From: Ben Daines [REDACTED]
Sent: Wednesday, February 19, 2020 11:39 AM
To: Maria Tomalova <Maria.Tomalova@arun.gov.uk>
Cc: Luke Torres <[REDACTED]> Martyn White <Martyn.White@arun.gov.uk>; Chris Barker [REDACTED]
Subject: RE: Y/105/19/PL & Y/106/19/L

Y/105/19/PL & Y/106/19/L

The proposal is for the conversion of, and alterations to, existing barns to create 3 dwellings, along with the erection of car barns, a store, a replacement pump house, demolition of a C20 barn and associated landscaping and parking.

Drawing Title
Proposed Plans - Barn 1

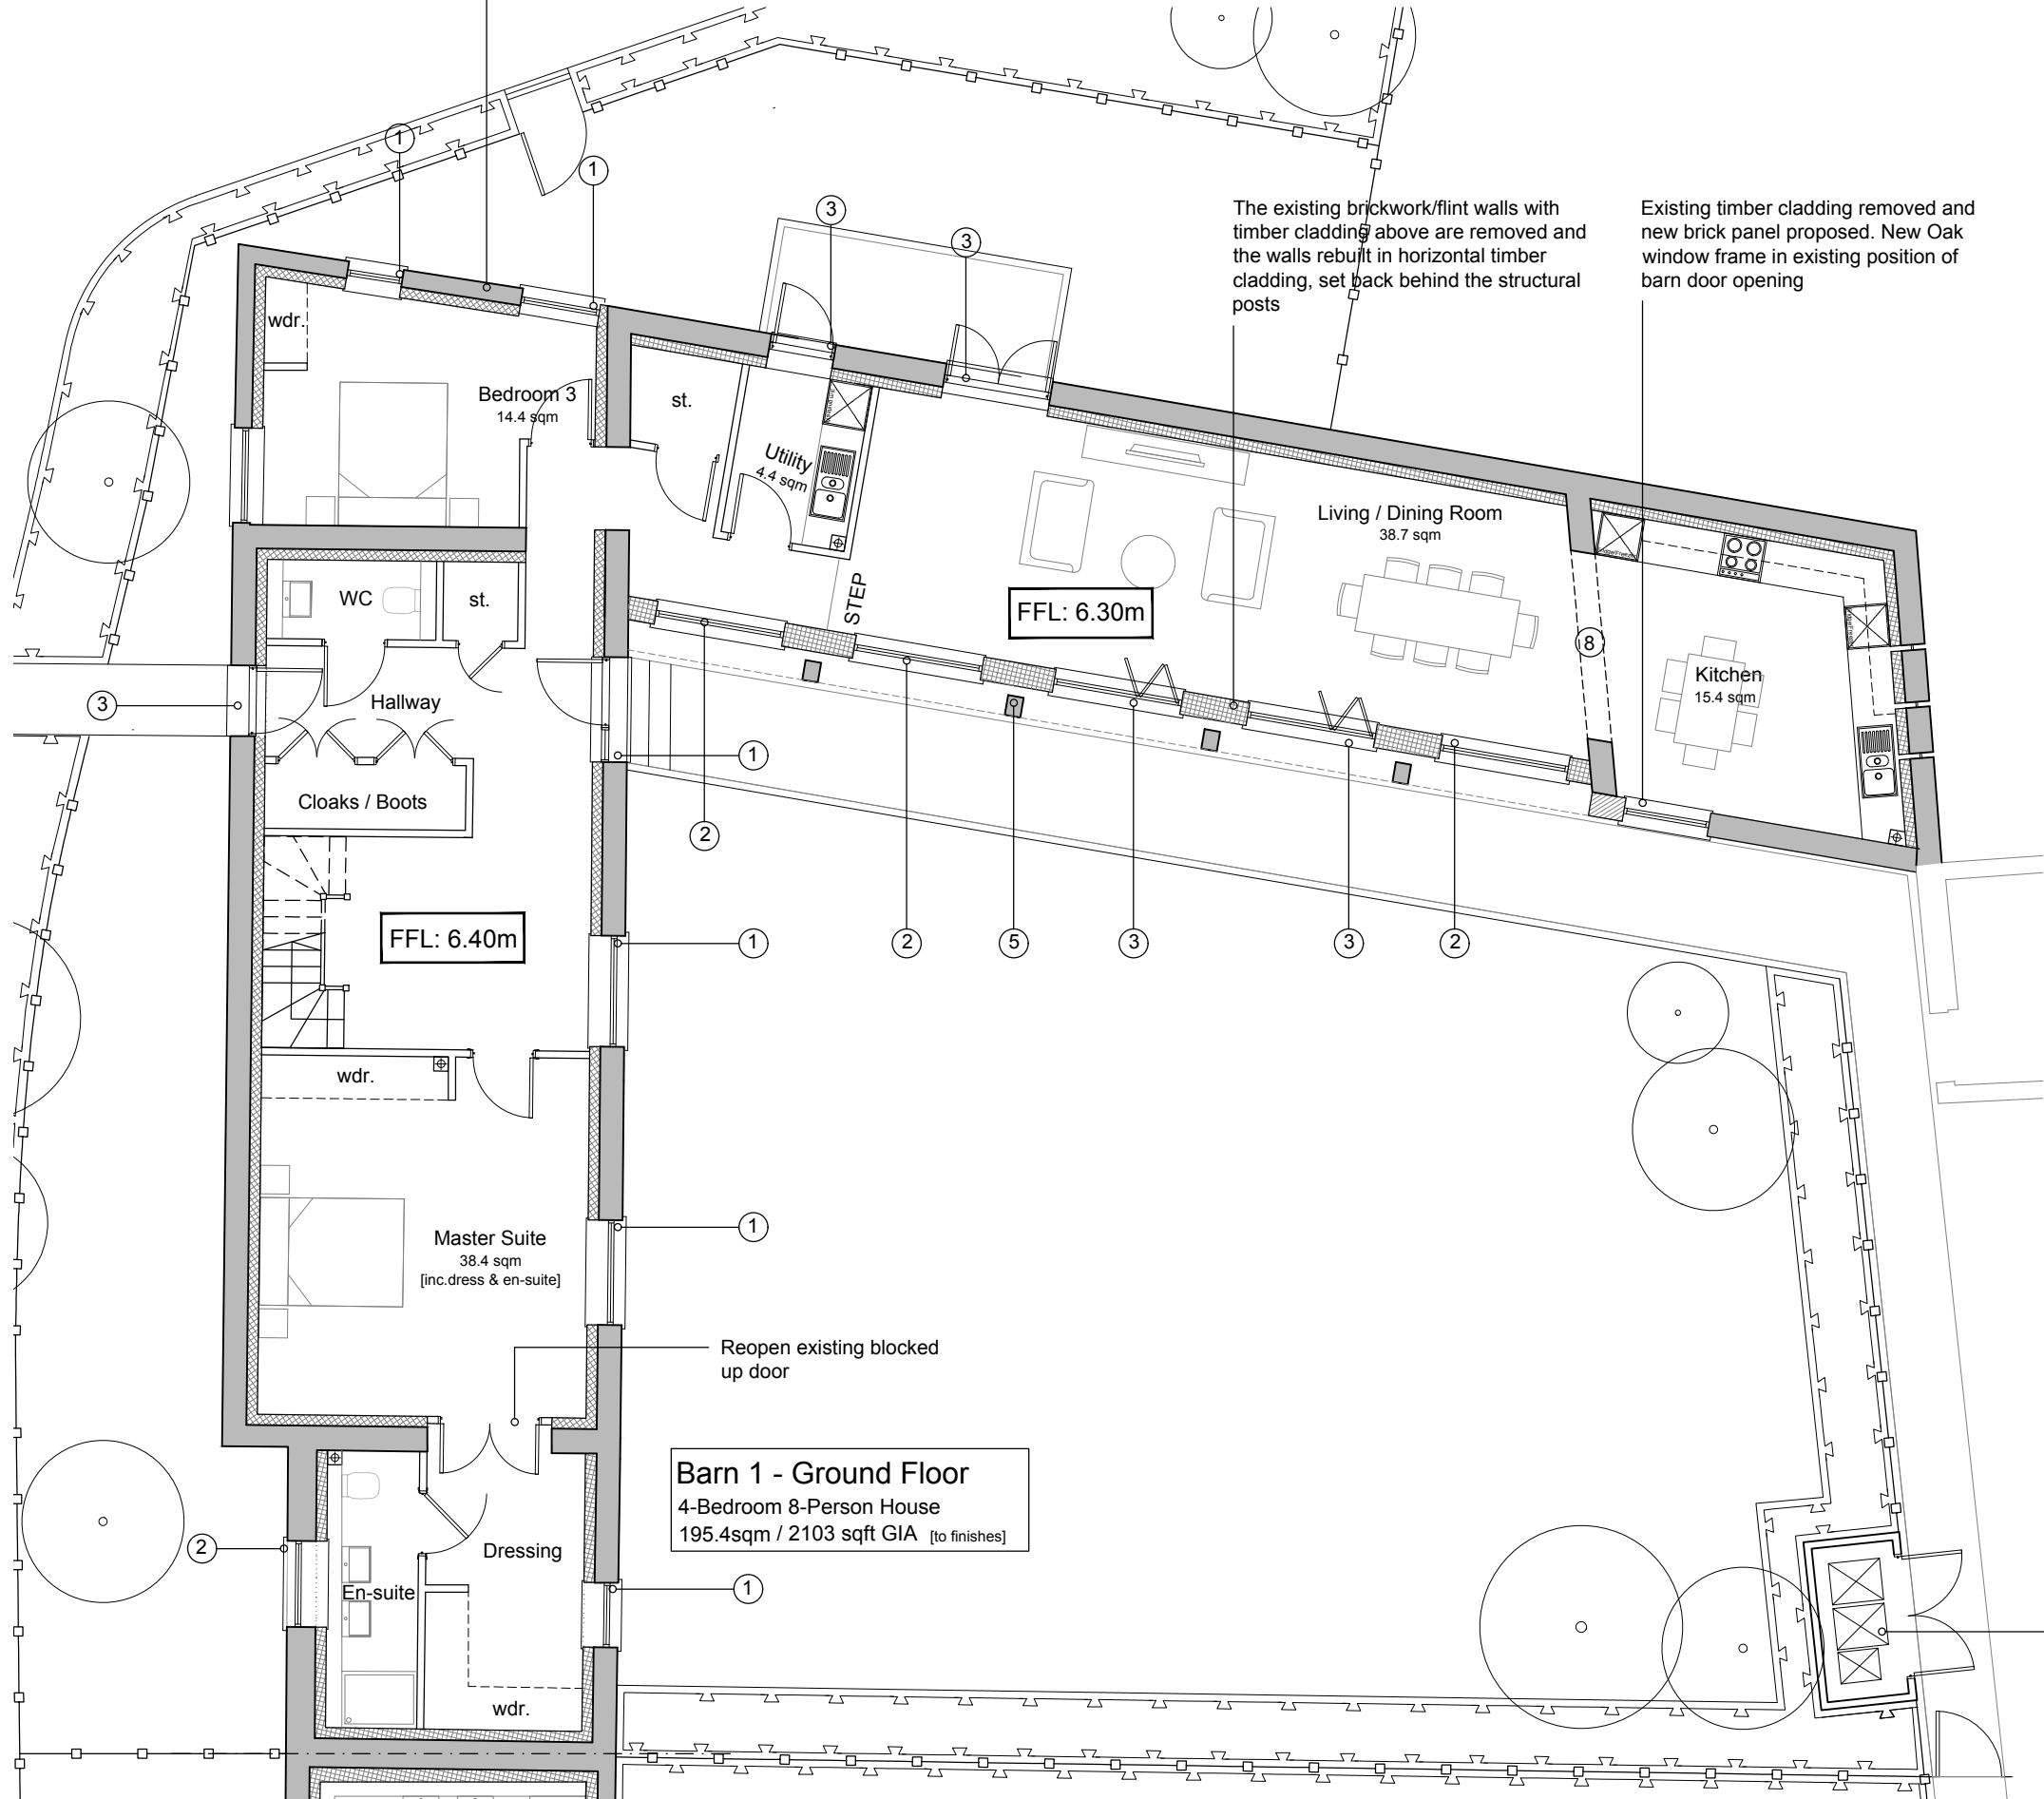
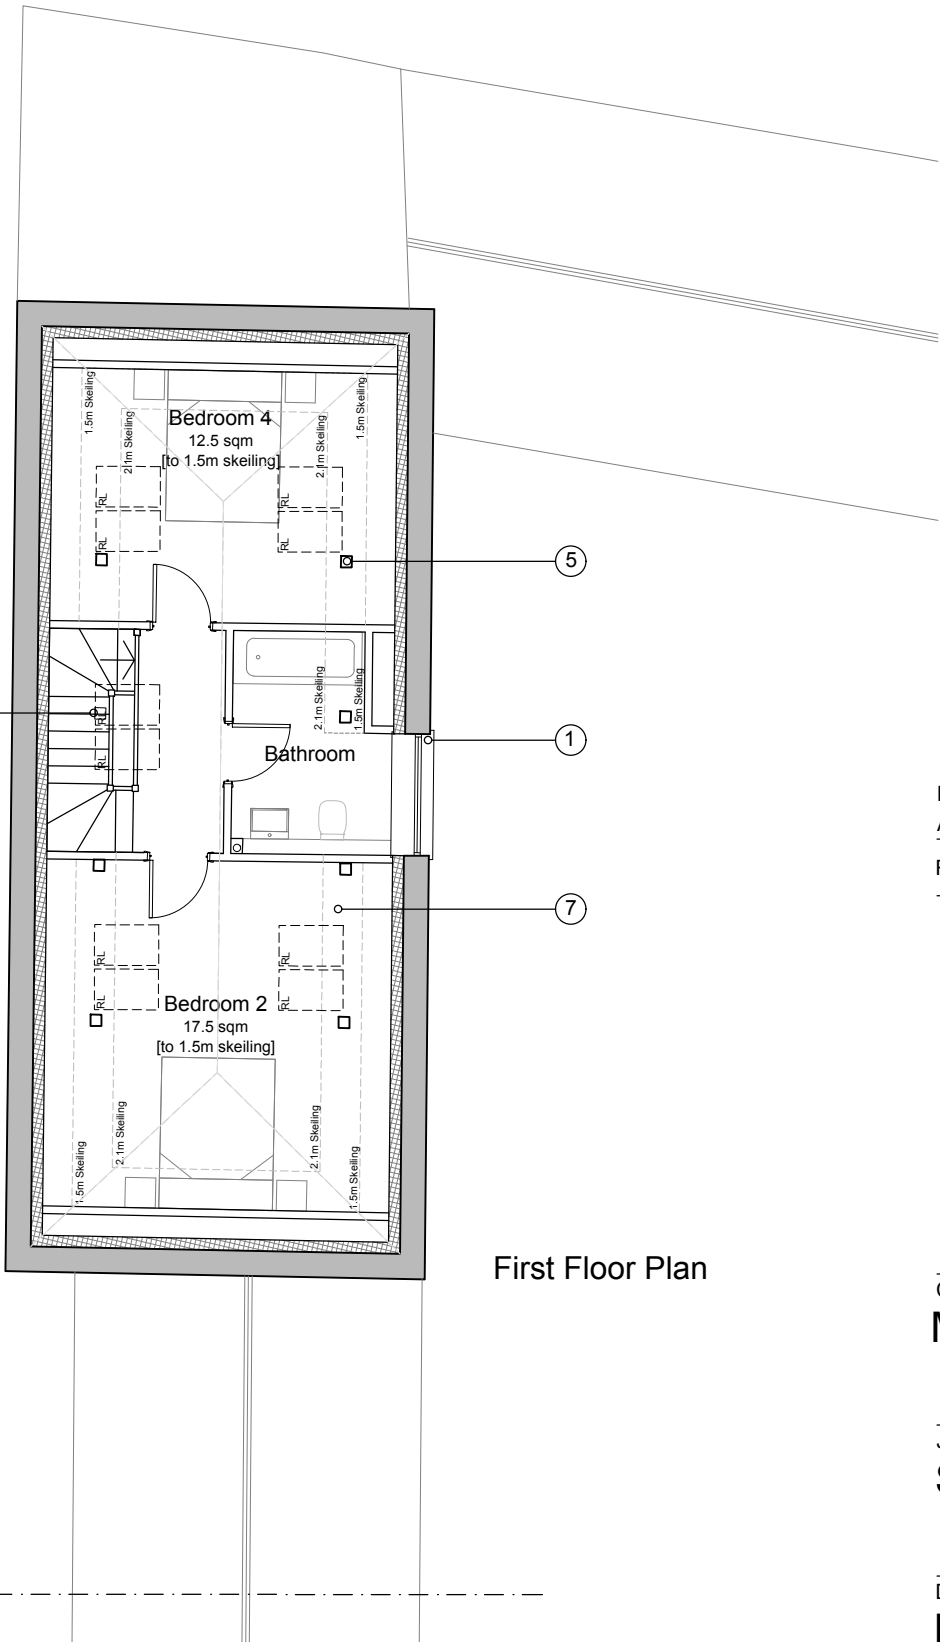
Having undertaken a site visit it is clear that some parts of the barn to be converted into unit one retains some attractive features, especially within the two-storey element. These features are some of the most attractive within the barns. These features include flint flooring, exposed brick walls, timber ceiling and stall dividers. The proposed plans indicate that this area is to be sub-divided up into smaller areas/rooms with a new staircase, yet it is not clear how these important features are to be retained.

Likewise, in building one, it is noted that an elevation will be altered in order to expose the previous cart barn openings. Such a proposal is generally acceptable, but the design of the new elevation, which includes excessive amounts of glazing, should have a simple framed emphasis and be recessed as far as possible to allow a deep shadow line. Such an approach also minimises reflections to reduce the visual prominence of the glazing. This technique can also help to maximise light penetration into the interior. Details of the fenestration along this section of the elevation should be carefully considered in order to ensure that they do not dominate the elevation.

There is some concern regarding the amount of rooflights proposed. Are so many necessary?

Our design approach has been to accentuate the most attractive features of the barns wherever possible however, but we have had to be realistic on what features we can retain in order to make the houses fit for habitation. For instance, the flint flooring will need to be taken up and appropriate damp proofing, insulation and floor finishes laid to meet building regulation requirements for habitable dwellings. We can however look to re purpose the flint from this area within the car barns or possibly as a feature within the central courtyard space. Similarly, we will need to dress the exposed brick walls with insulation and plasterboard to suitably insulate the dwelling. Whilst the brick wall may not be a feature within the dwelling, this approach will help to protect the wall and offer further longevity to the barns. Where possible the existing timber first floor will be retained as a feature with new insulation and floor finishes dressed on top to meet building regulations for the habitable rooms.

Your comments are noted regarding the window openings and we would assume that they would form part of a planning condition that covers the key construction detailing you wish to be agreed. The window reveals will form part of the detailed design package when the proposed wall build ups are established and we determine how this meets the window/door junctions. In an attempt to reduce the prominence of glazing along the elevation we could reduce the window sets from three pane to two panes, with the door openings becoming simple double opening doors as opposed to bifold. Please see the attached mark up.

It is intended for these rooflights to be conservation lights which are more sympathetic to the existing character of the barns. With this being said there are some areas within the scheme where the number of rooflight can be reduced, please see our mark-up of the plans an elevation for a suggested solution.
